KITITAS COUNTY

MEMORANDUM

SUBJECT: LPF-20-00014 Palomino Fields Plat Division 4

Surveyed by LMH	Scale 1" = 100'
Drawn by Tml/FCS	Sheet 2 of 6
Checked by FCS	Project No. 18146

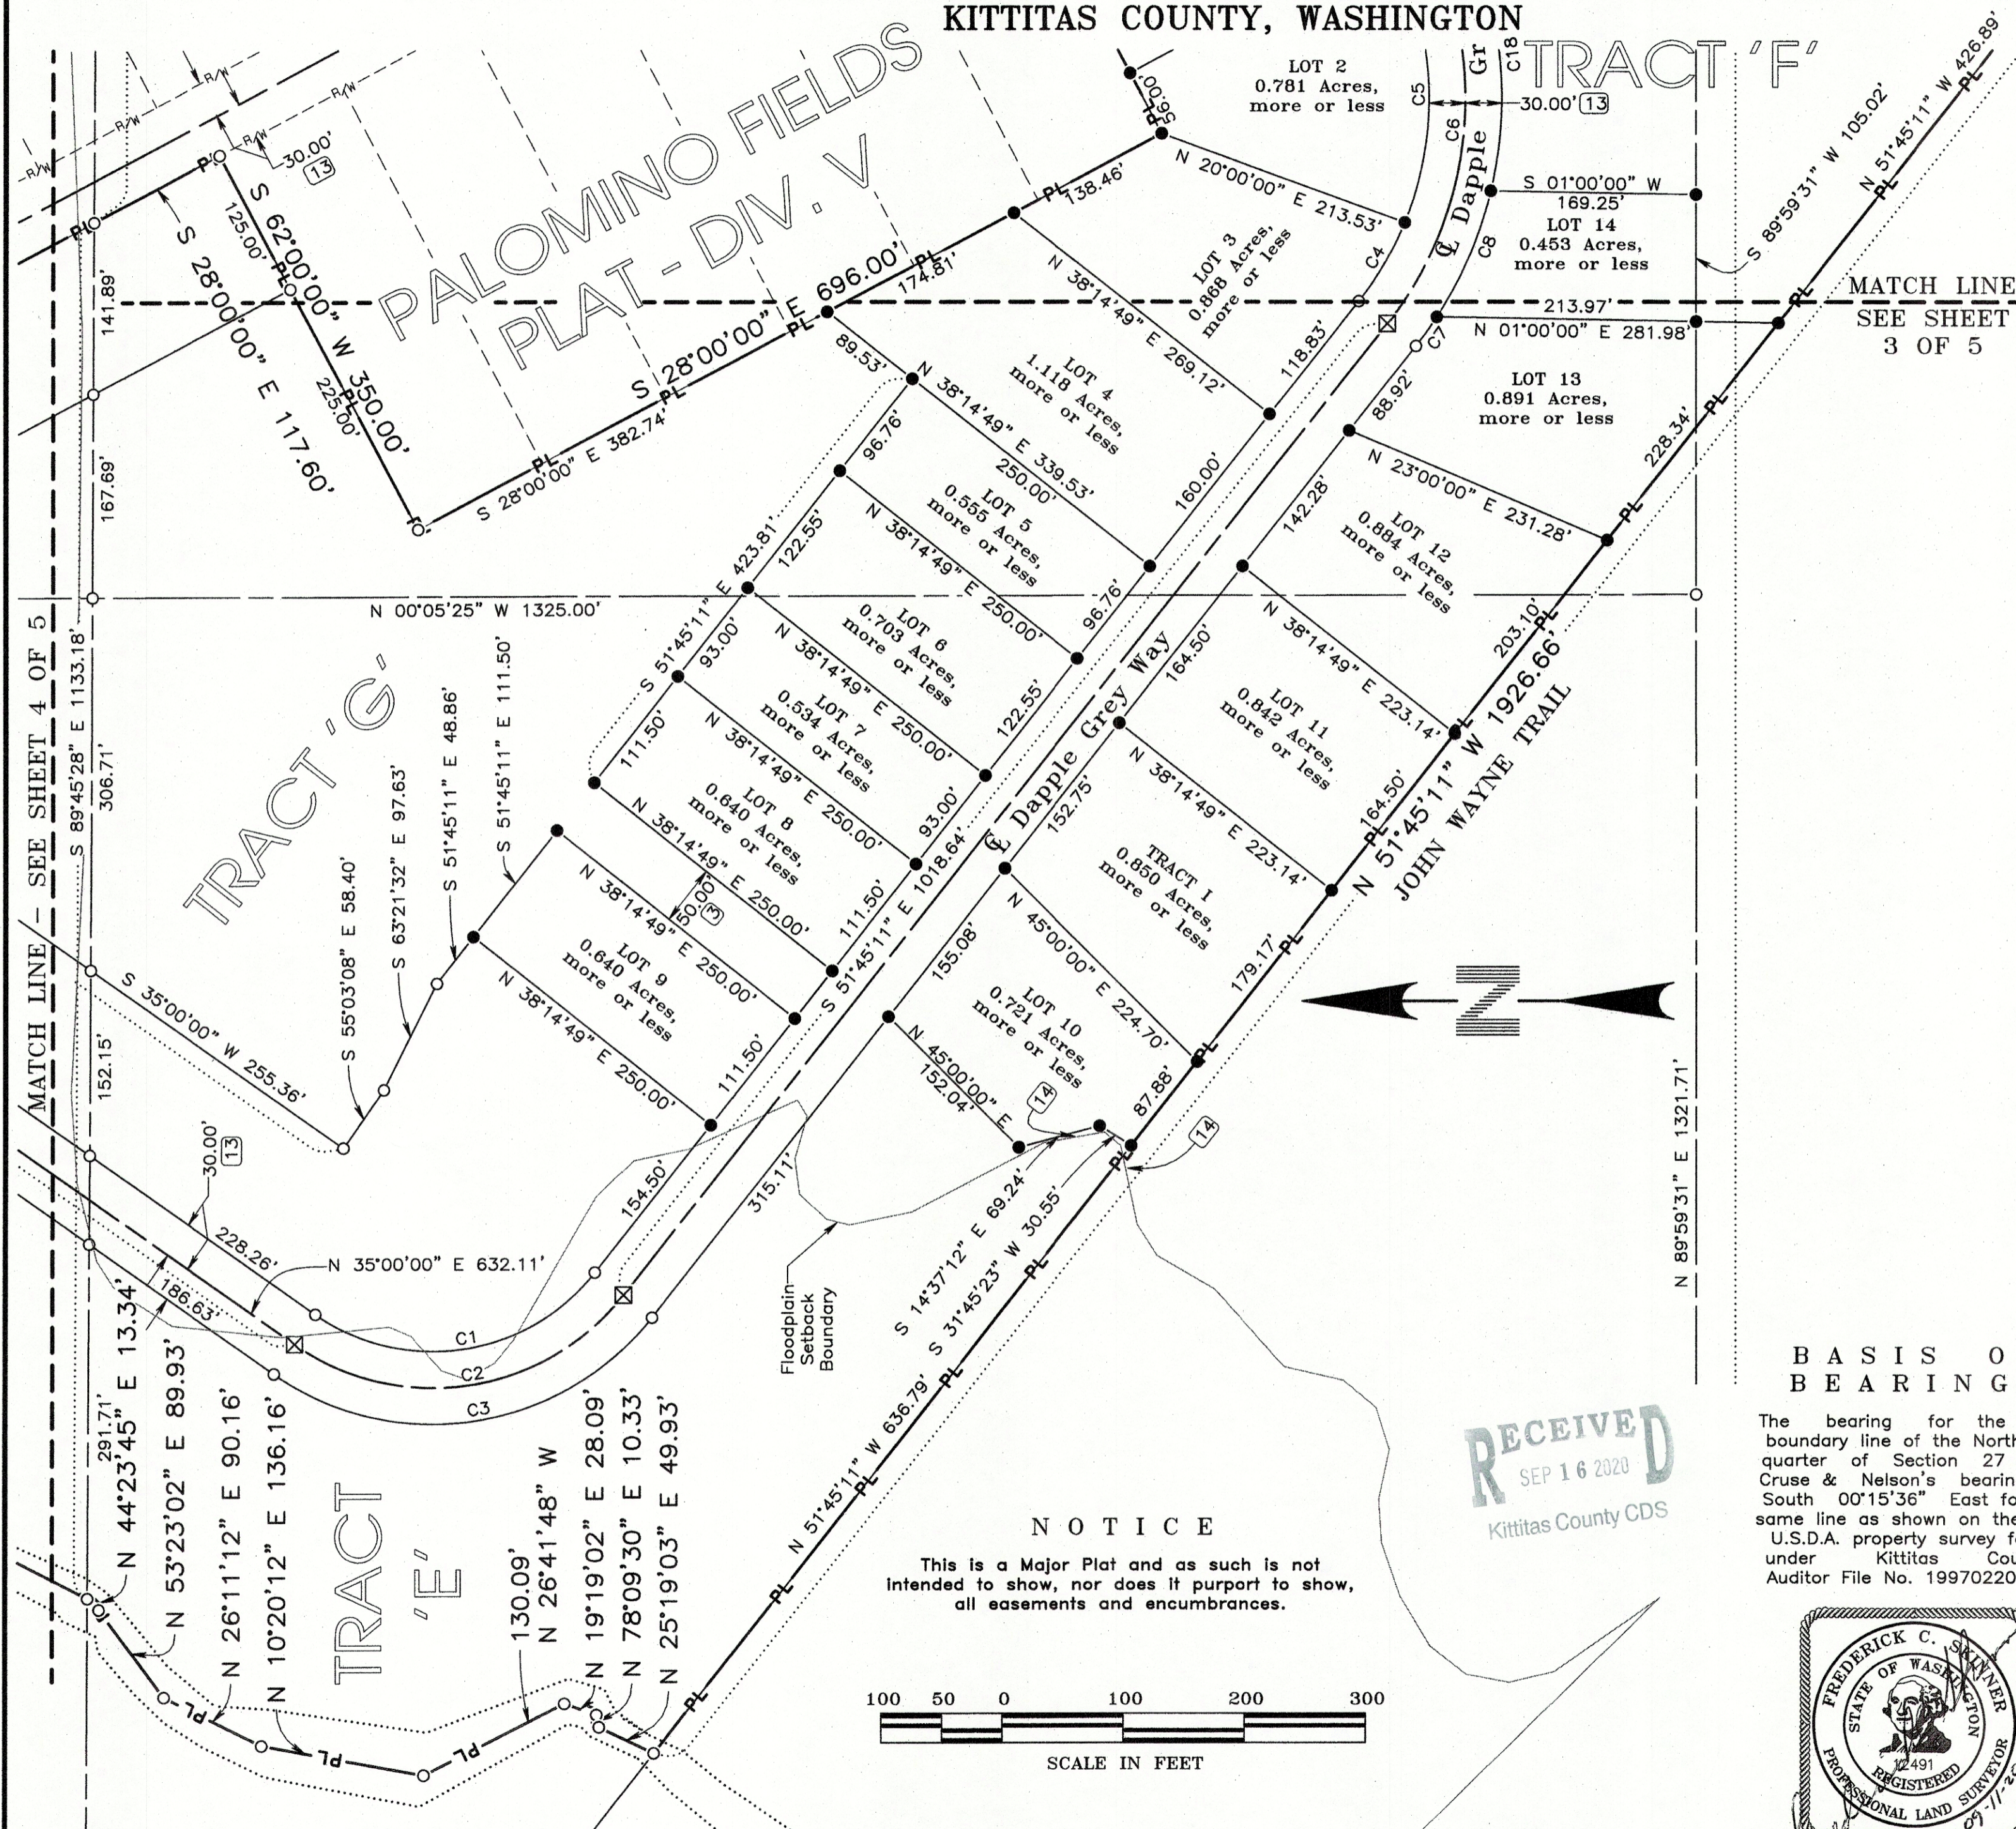
1. The Southeast boundary of Lot 3 is missing a distance of 118.83'. (sheets 2 and 3).
2. Curve C7 on Lot 13 appears in the closure report as a line. (The Surveyor can check this and see that lot areas and curve labeling is correct, there is no need for a revised closure report).

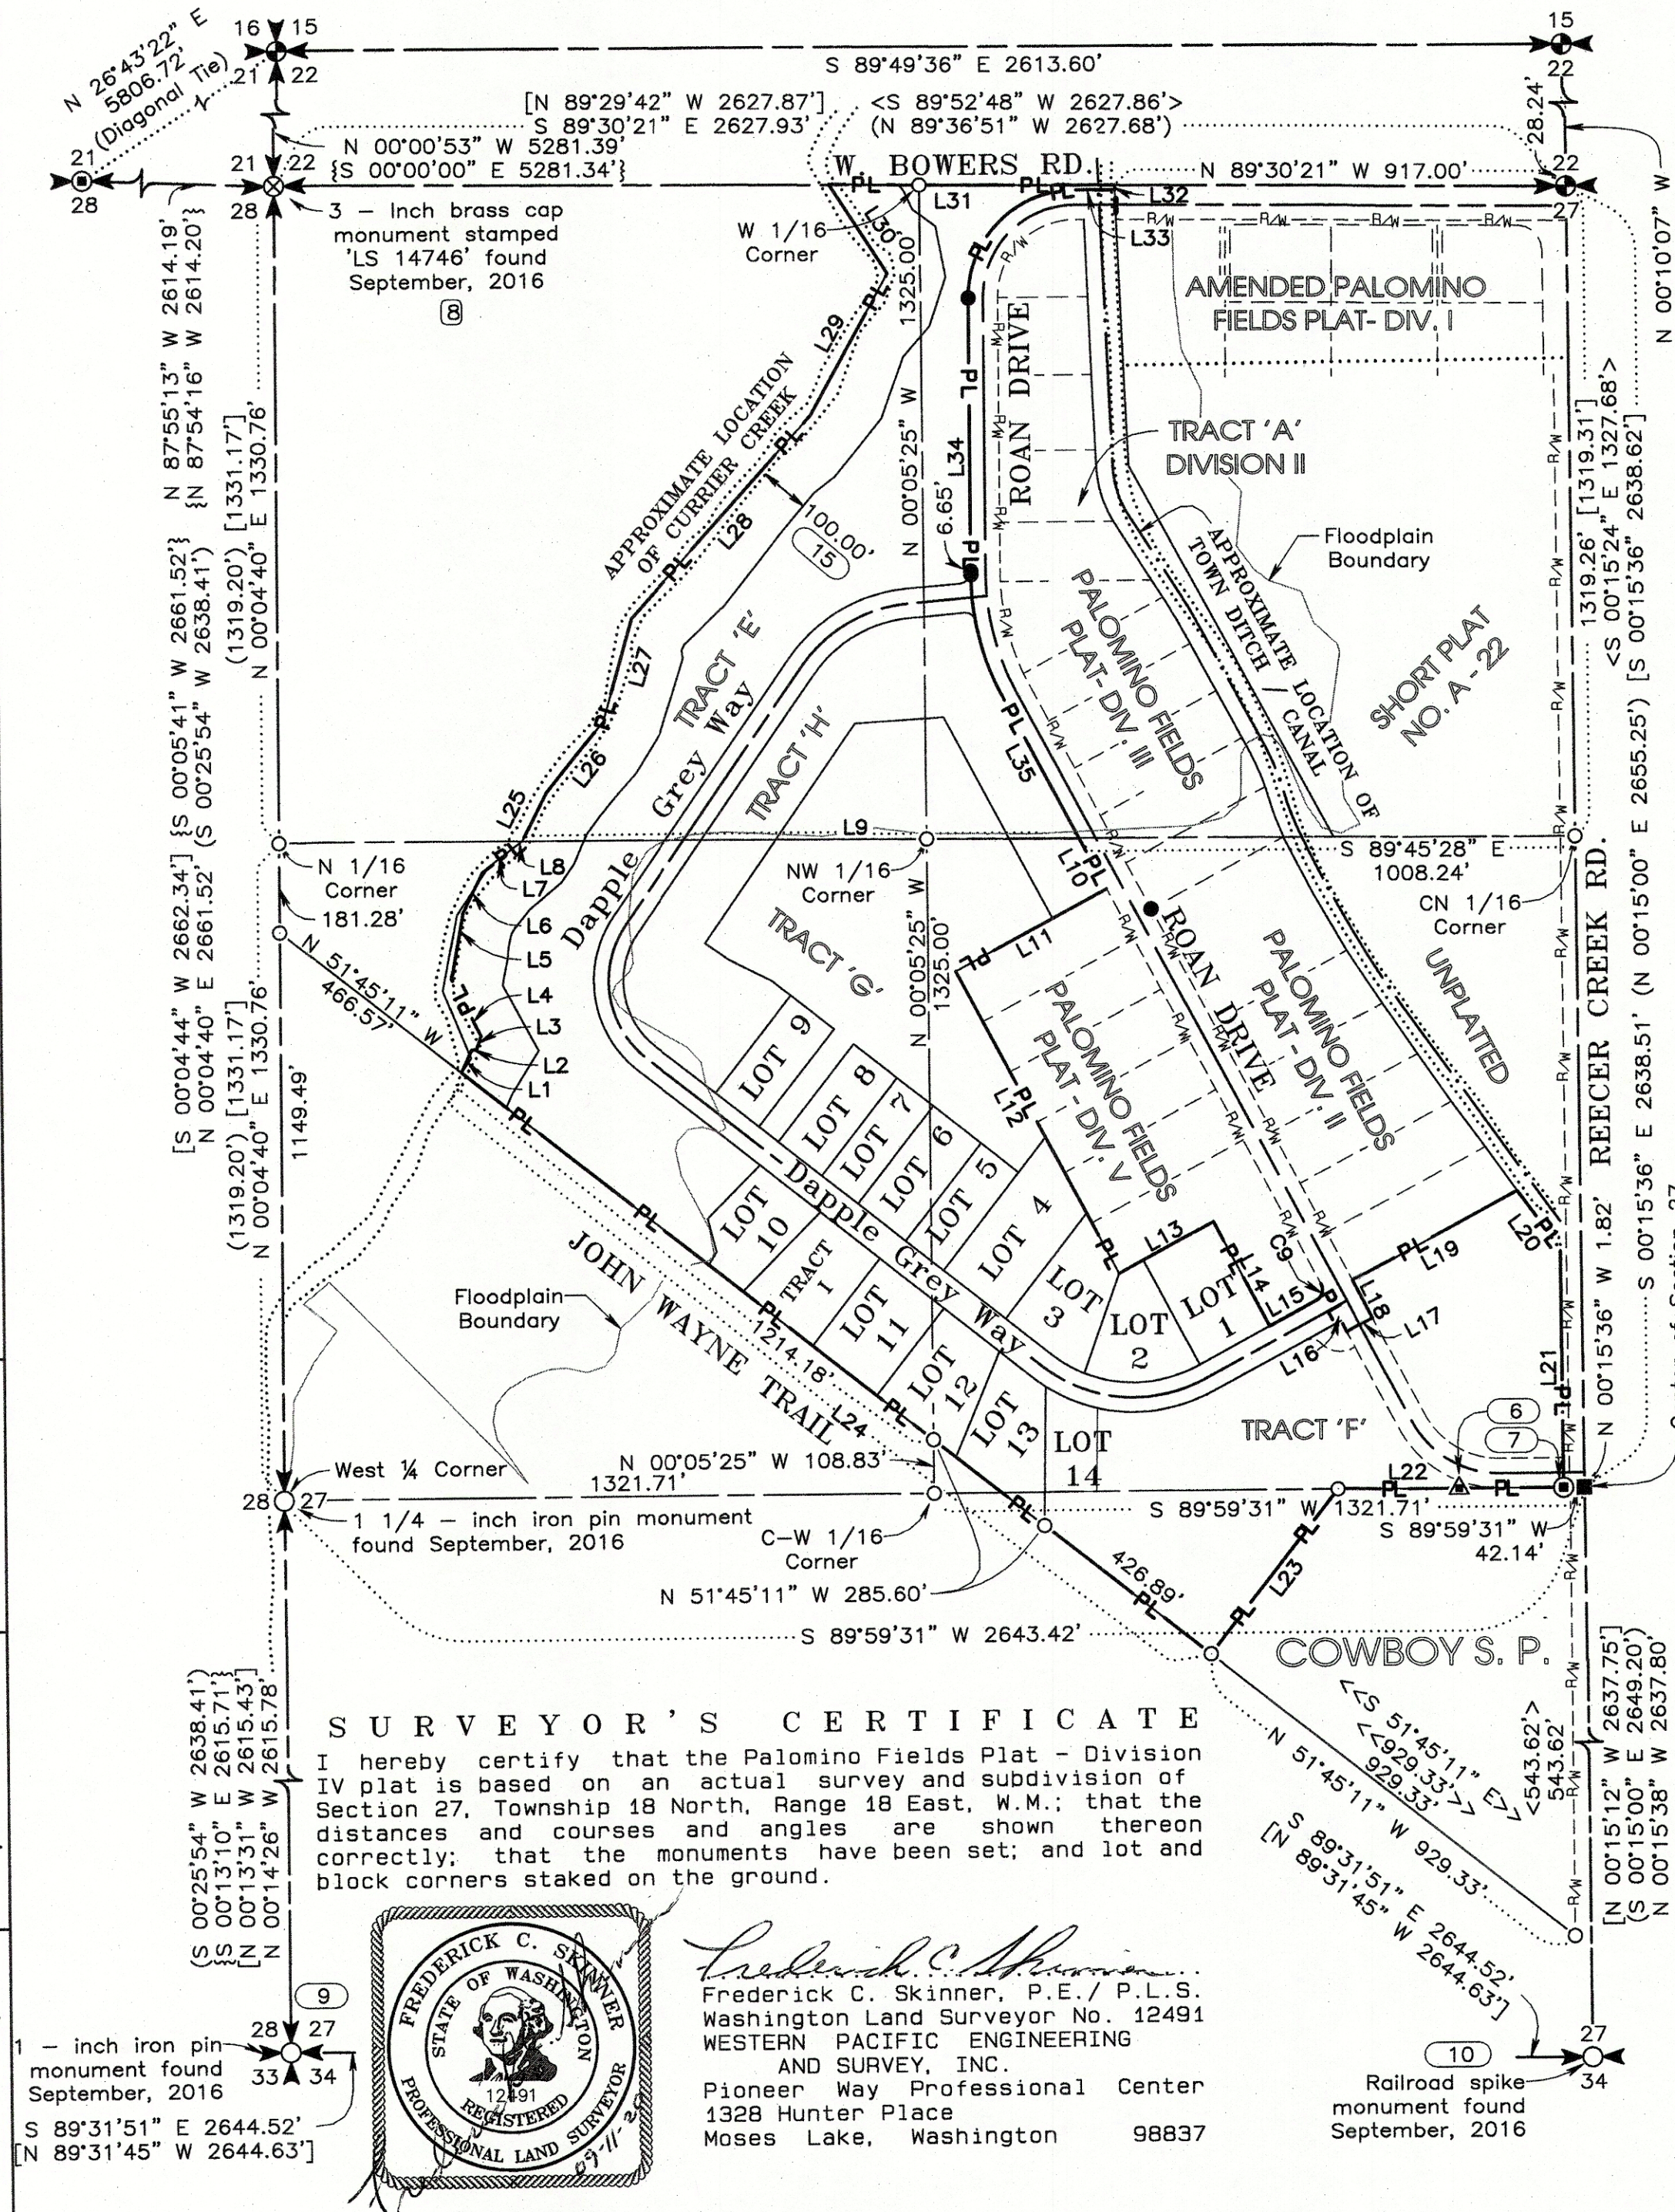
On page 1 – the Floodplain Boundary label should be updated to identify the boundary as the 100-Year Floodplain Boundary.
